Engineers Comments Regarding Surface Water Drainage

Application Reference:	CM/11/26/DOC	Reviewer Reference:	ADC/EXT2
Planning Officer:	Kathryn Welch	Date of Review:	22/06/26
Site Name:	Rigates Climping Street Climping BN17 5RQ		
Application Description:	Approval of details reserved by condition under CM/12/25/PL relating to condition 3- Surface Water Drainage.		
Assessment Number:	1 of 2

DWG Title	CATCHMENT PLAN	DWG No	HC-4274-001
-----------	----------------	--------	-------------

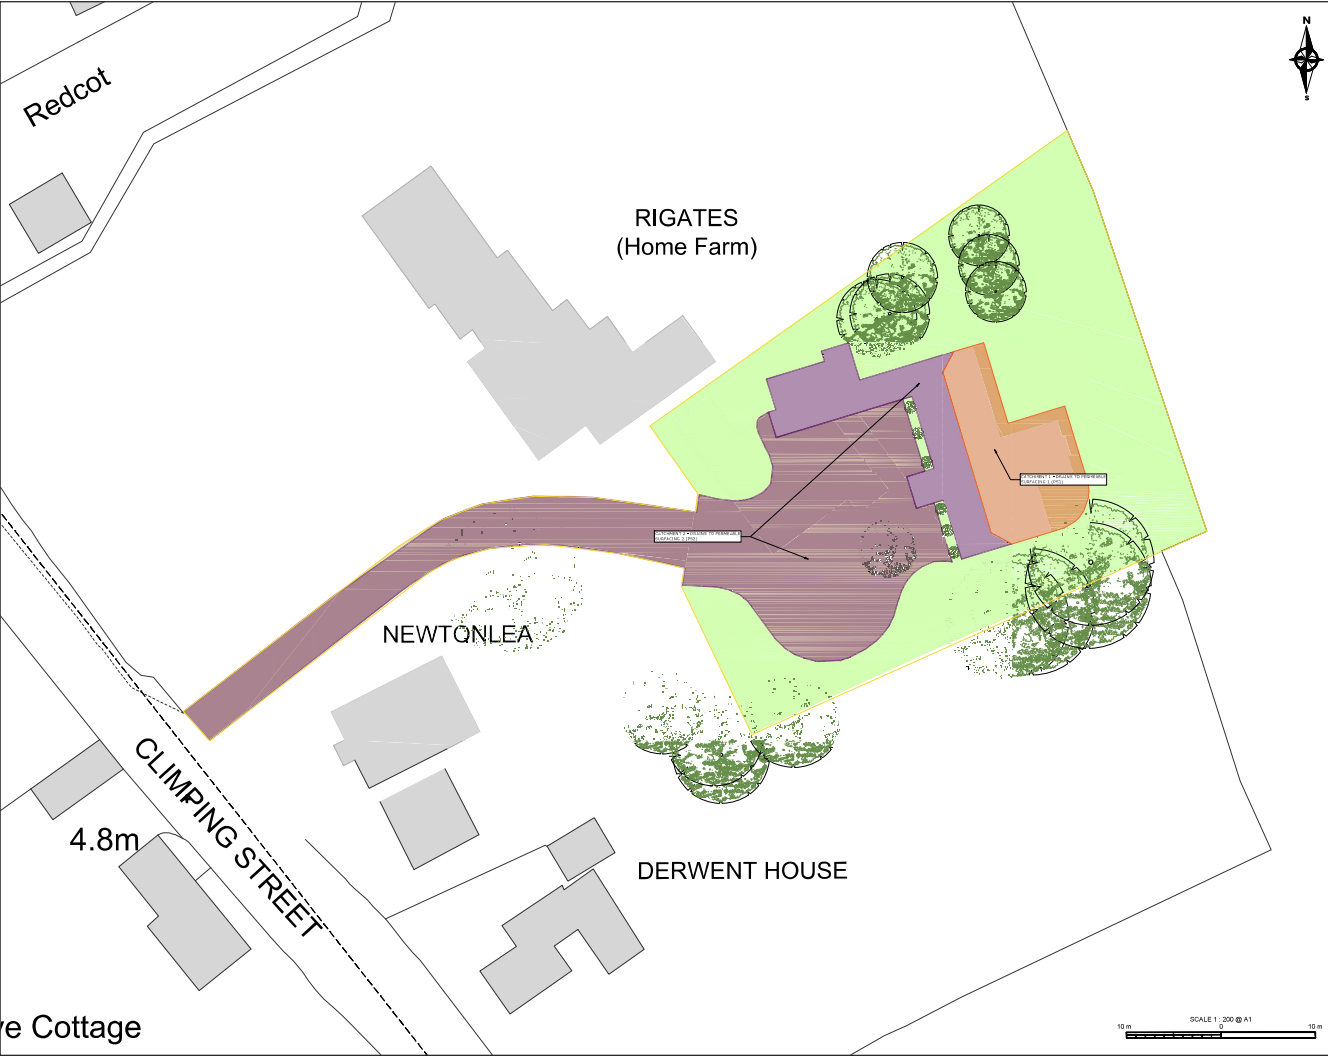
- 3.1. In principle, the method used in the calculations is accepted, the FEH rainfall data file should be emailed to land.drainage@arun.gov.uk
- 3.2. Details of the existing and proposed external levels have not been submitted. This is required to verify the calculations.
- 3.3. A plan has not been submitted that cross references with the calculations.
- 3.4. It has not been demonstrated that capacity exists in the public sewer network to accept the proposed flows.
- 3.5. A catchment plan should be provided which can be cross referenced to the calculations and including how urban creep has been applied.
- 3.6. There does not appear to be an allowance for surcharging of the outfall
- 3.7. There does not appear to be an assessment of the impact that a flood event would have on the proposed surface water drainage system.

4274.DWG.d4
SURFACE WATER DRAINAGE
LAYOUT
HC-4274-501

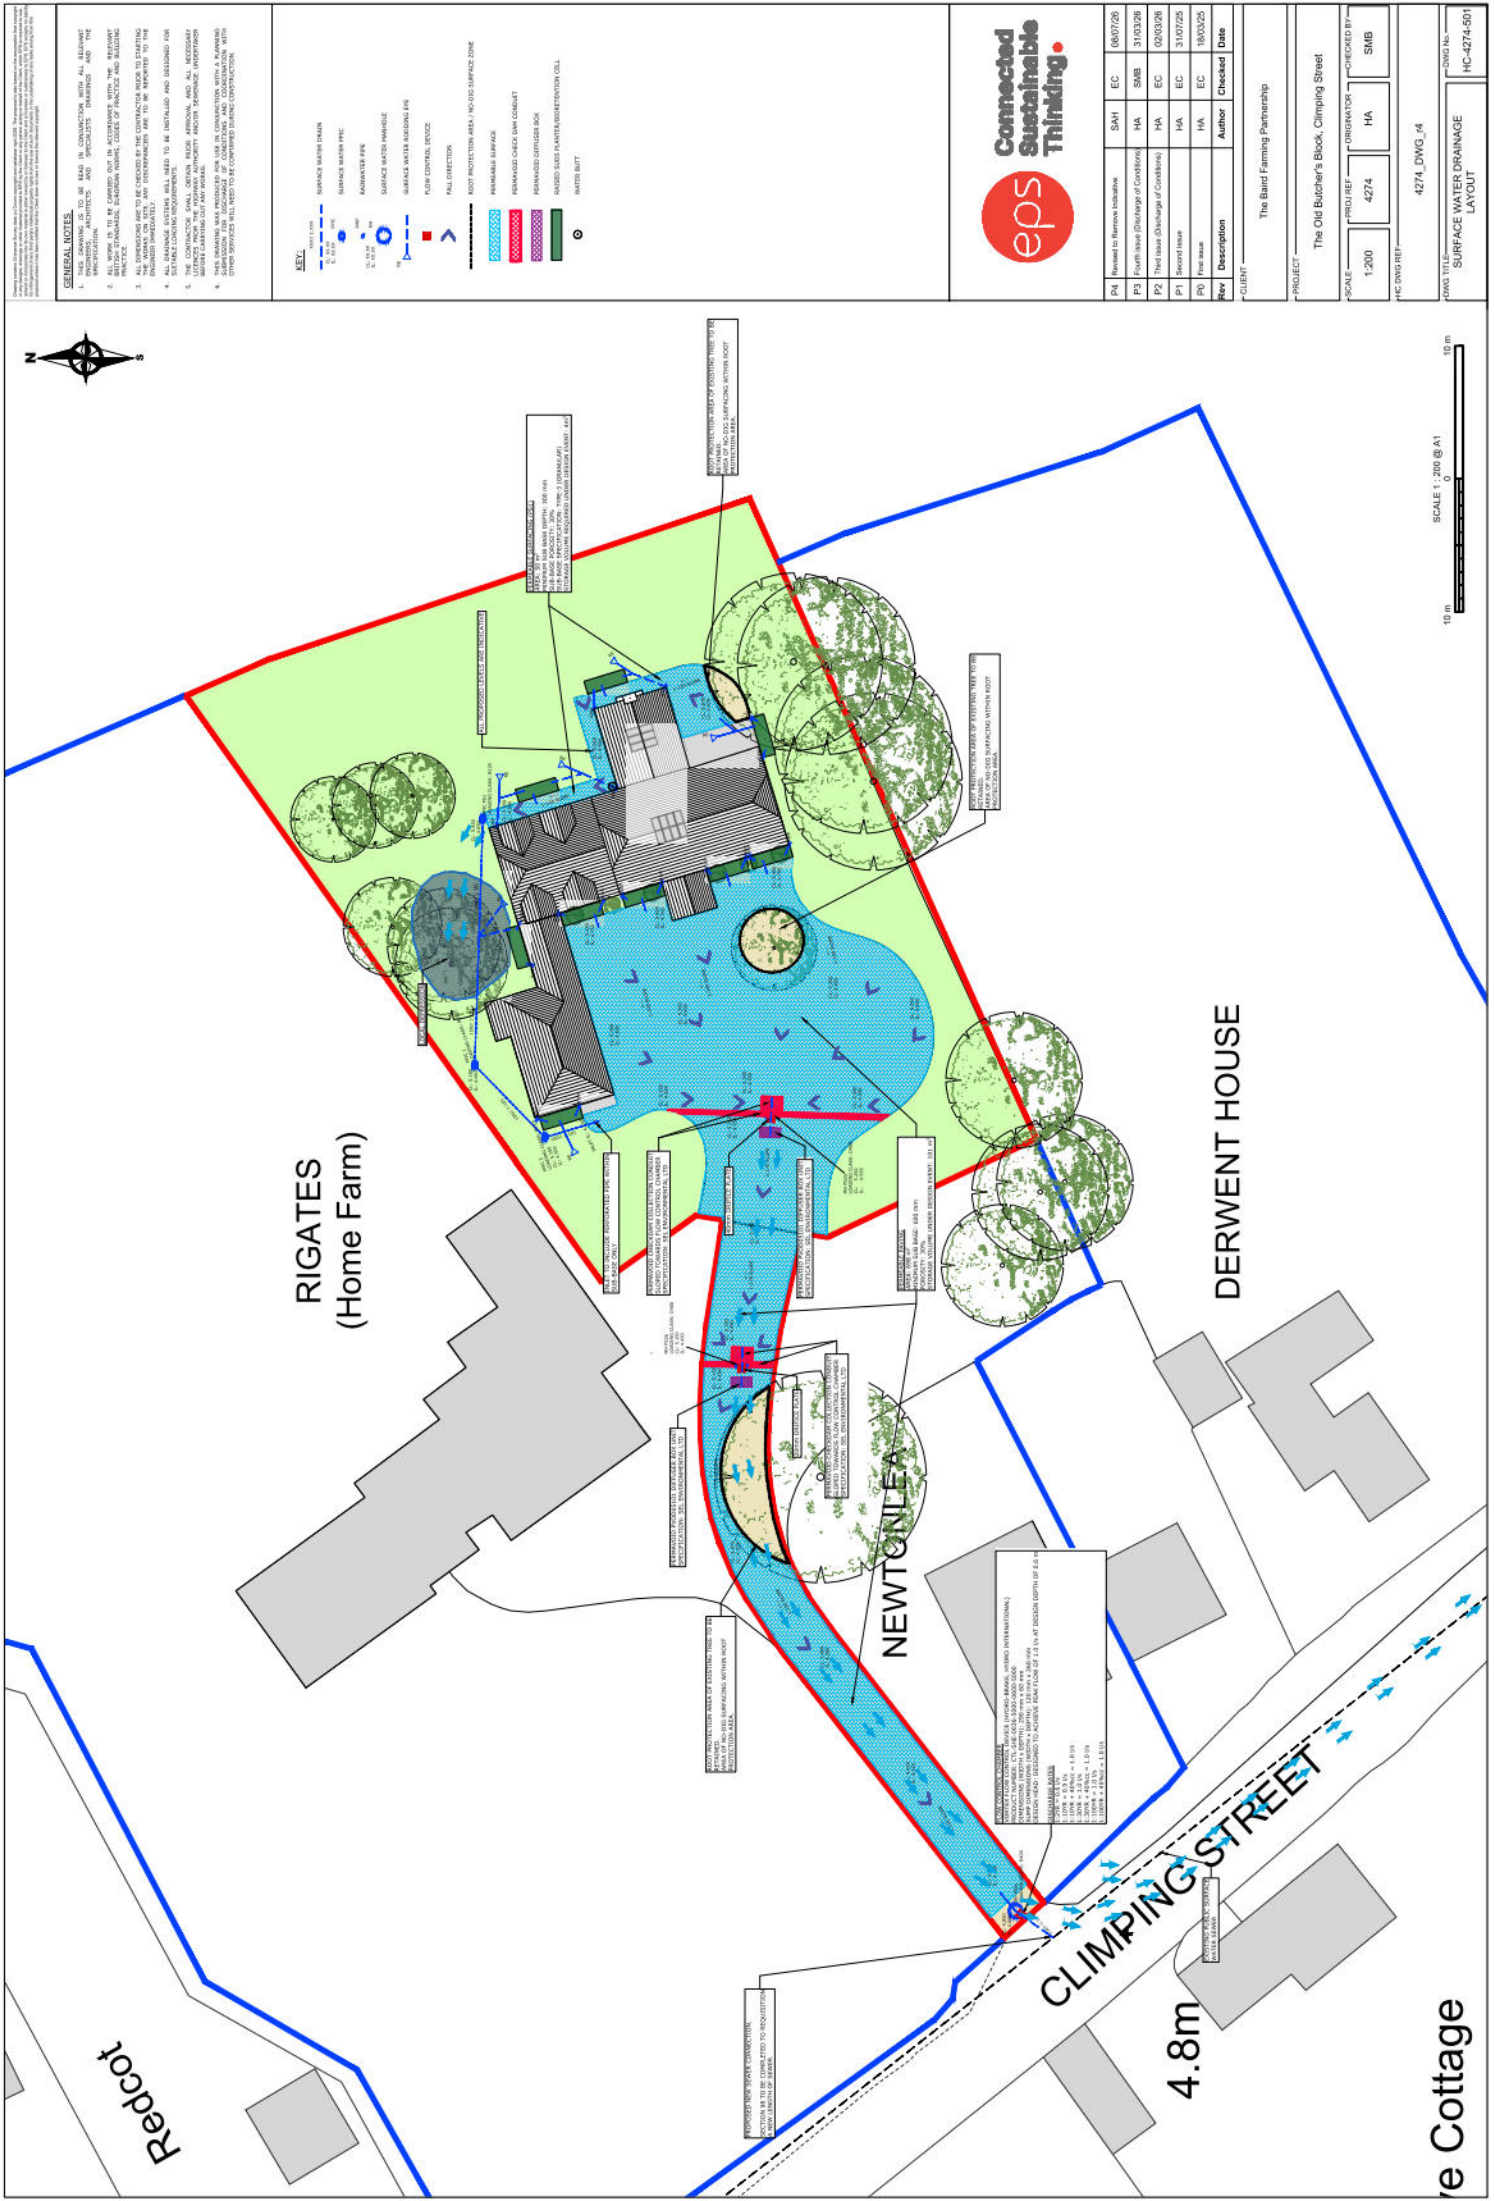
- 2.1. Water reuse is acknowledged the strategy as being part of the SuDS hierarchy but it does not appear to be proposed and no reasons are given to justify why.
- 2.2. The strategy includes the installation of downpipe/SuDS planters, and it is stated that this will reduce the volume of run off discharged. This statement should be evidenced.
- 2.3. The inclusion of permeable paving when it drains its own catchment is considered to provide an adequate level of interception, however the plan appears to show the runoff from the roof connected to the permeable paving. Further interception measures may be required for the roof run-off, if evidence of evapotranspiration cannot be provided for the downpipe/SuDS planters.

7.1. The submitted drawings are indicative, construction level information is required.

surcharging of the outfall (Standard 3)				
10	Demonstrate how the surface water drainage design is integrated with amenity. (Standard 5)				
11	With regard to biodiversity, the provision of downpipe/SuDS planters is acknowledged. An assessment of the impact of these must be provided (Standard 6).				
12	Provide fully detailed and coordinated construction level drawings. It is recommended that reference is made to the checklist available on Arun District Councils website. (Standard 7)				
13	Provide full details/ specifications for all SuDS features/products. If additional information is required from other consultants, it should also be provided. (Standard 7)				
14	The CL and IL shown on the plan on permeable paving at the rear of the building indicate a total depth of construction of 600mm. This does not appear to coordinate with the

permeable paving detail Type A. (Standard 7)				
15	The CL and IL shown on the plan on permeable paving in the driveway indicates a total depth of construction of 700mm, suggesting 50mm thick blocks. Please confirm the product for this block thickness. (Standard 7)				
16	Show clearly on the plan and sections which areas of permeable paving have which sub base thicknesses. (Standard 7)				
17	Demonstrate that soil particles/fines from the SuDS planters will not migrate to the permeable paving sub base.
